Application for a Non-Material Amendment Following a Grant of Planning Permission

Erection of 2 detached dwellings with associated parking, access and infrastructure (to include demolition of existing garage building and retention of existing dwelling)

22/0062/FUL

Amendments to design as follows:

| PROJECT No: 23/402 | DRAWING No: 23/402 E01 | REVISION C |

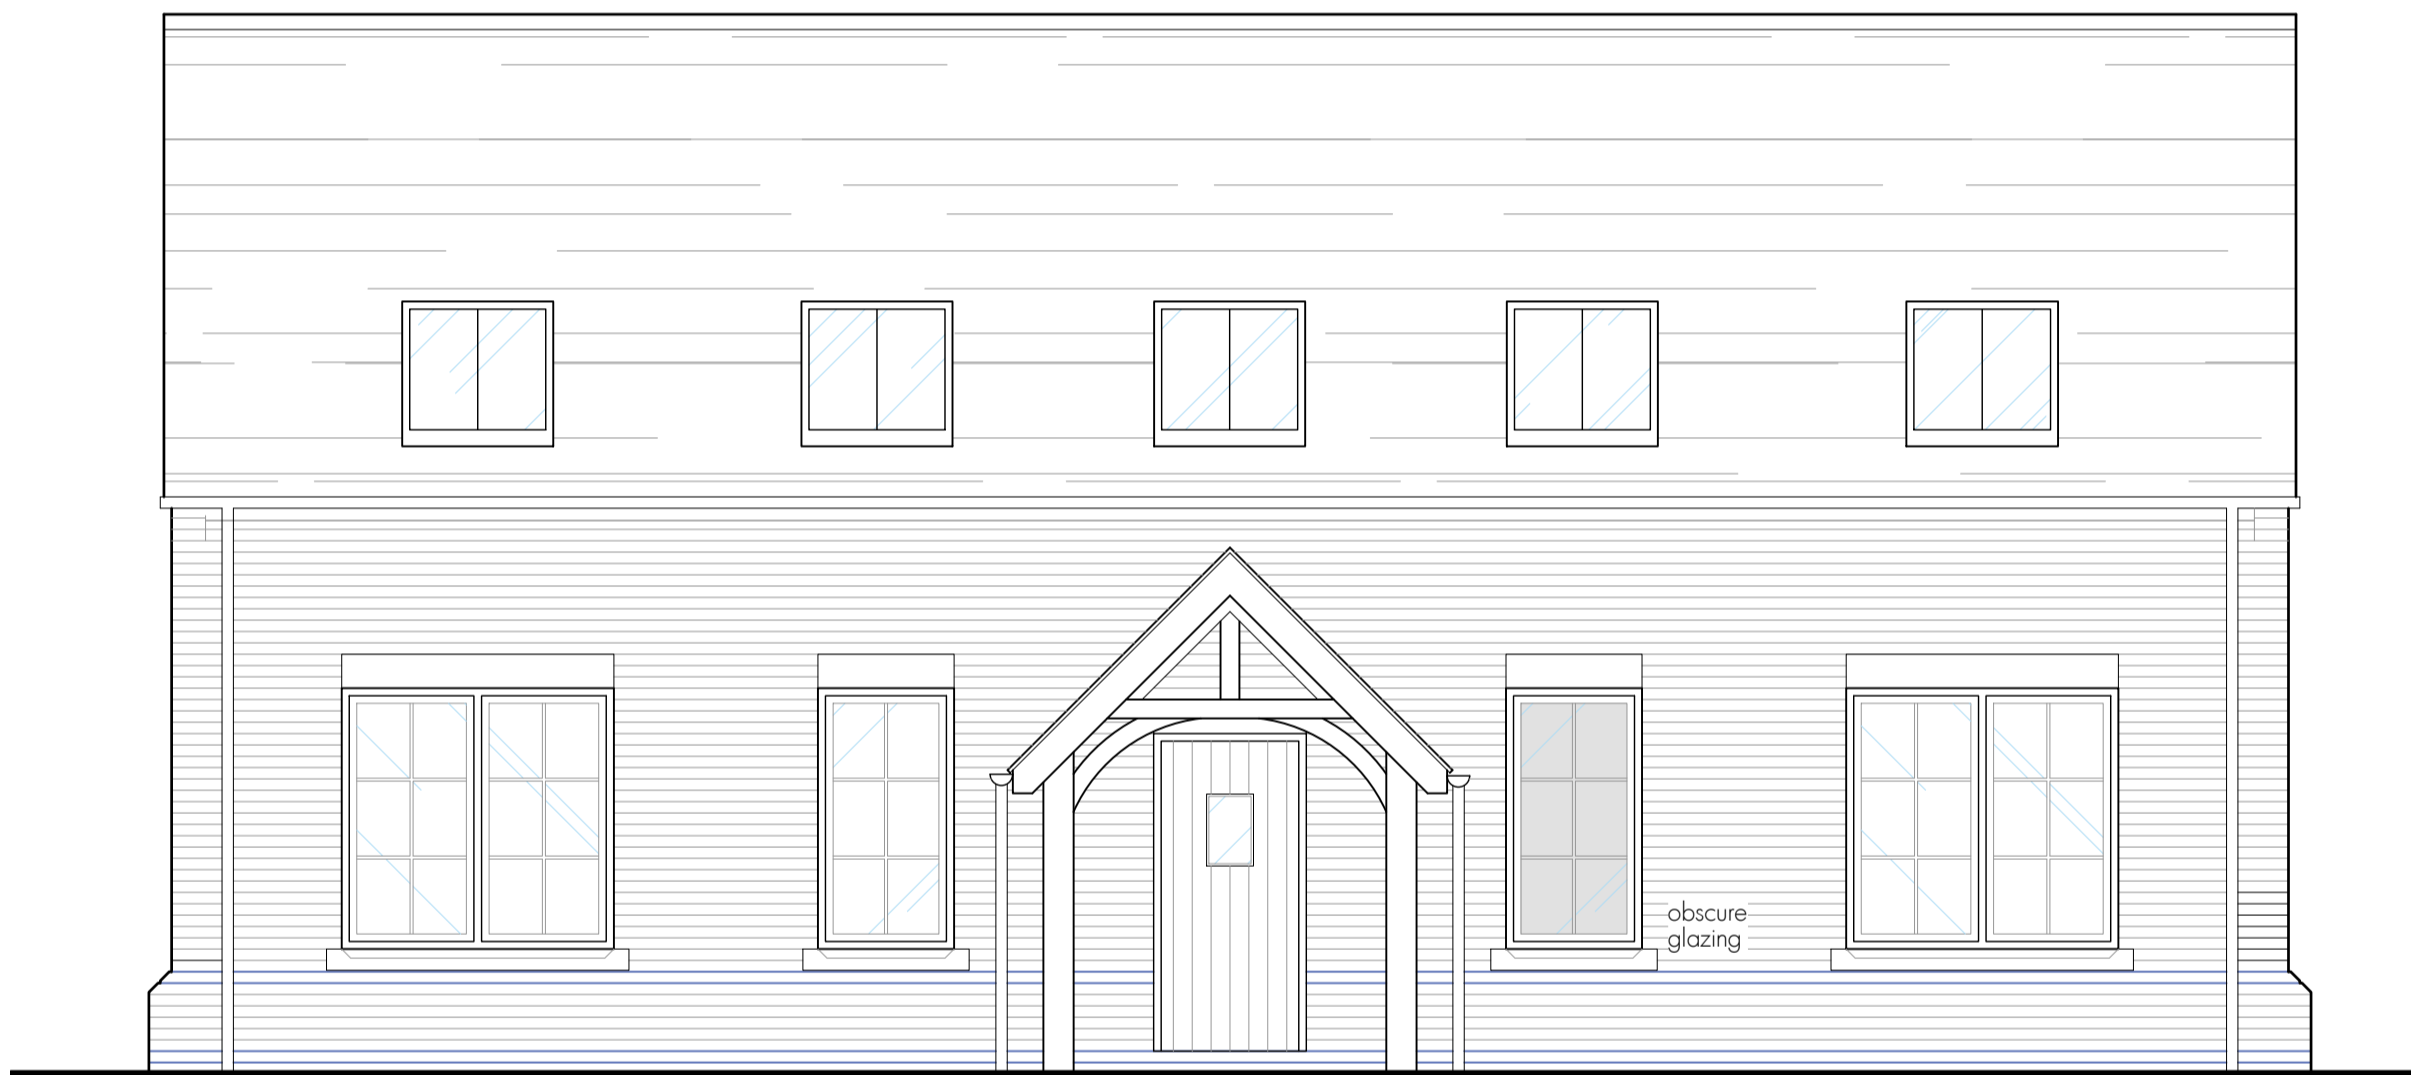
1. Ground floor rear elevation door/window locations amended.
2. Grey panel and surround removed from ground floor rear elevation doors/windows.
3. First floor rear elevation window cill heights amended.
4. Juliet balconies added.
5. Rooflight dimensions amended.
6. Timber porch truss design amended.

1. Ground floor rear elevation doors/windows have been amended as they were shown incorrectly on the approved planning drawings when compared with approved plans.

2. Grey panel and surround (of unspecified material on approved planning drawings) has been removed from ground floor rear elevation doors/windows.
3. First floor rear elevation windows cill height have been amended because the approved elevations showed the windows below the first floor level.

4. Juliet balconies have been added to protect occupants from falling and in order to comply with Building Control (the windows would either need to be protected at low level or non-opening which would not have been possible as they are fire escape windows from bedrooms).

5. Rooflights have been amended to reflect actual dimensions as the rooflights on the approved planning drawings were shown as an arbitrary size which would have been either higher than the ceiling level or lower than the roof level and difficult to source at such a large size.

6. Timber porch amended slightly because the approved drawings show a curve which would be very difficult to construct and the proposed truss has been drawn to reflect the actual construction with a more representative curve.
